From: Simon Davis
Sent: 16 August 2018 17:13
To: 'BRYAN BUTCHER'
Subject: RE: 16, Vicarage Lane, Felpham - FP/104/18/HH

sheet 4 a of 6

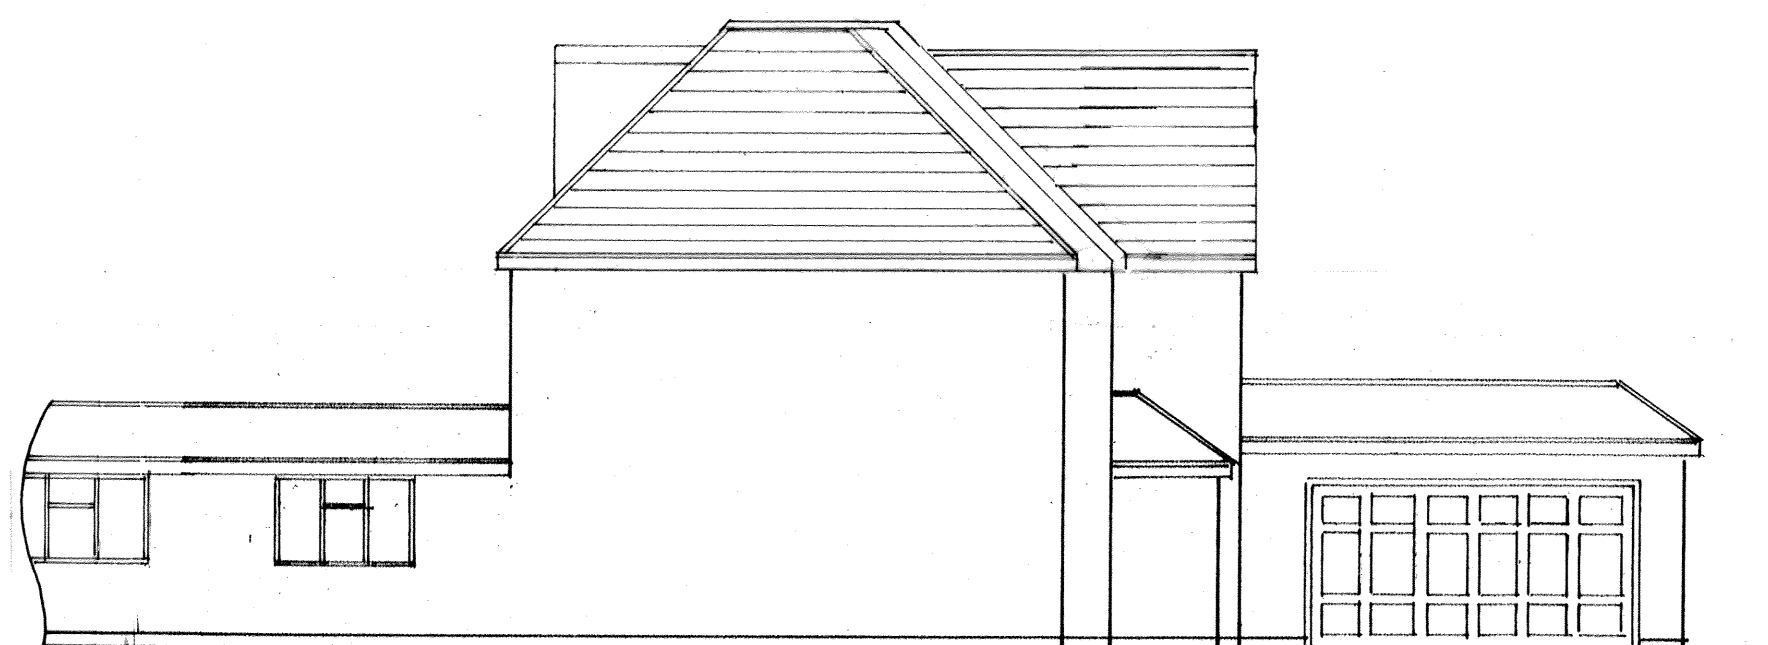
However, you should note that I have spoken with the Conservation Officer about the proposal and it is our view that the addition of the front dormers and the raising of the roof height will result in a dominating impact on the street scene and result in harm to the setting of the Conservation Area opposite and the setting of the Grade 2 Listed Building diagonally opposite. Therefore, my decision will be a refusal.

I can lower the ridge height and remove the front dormer if that helps.

I can let you have some amended elevations for you to consider.
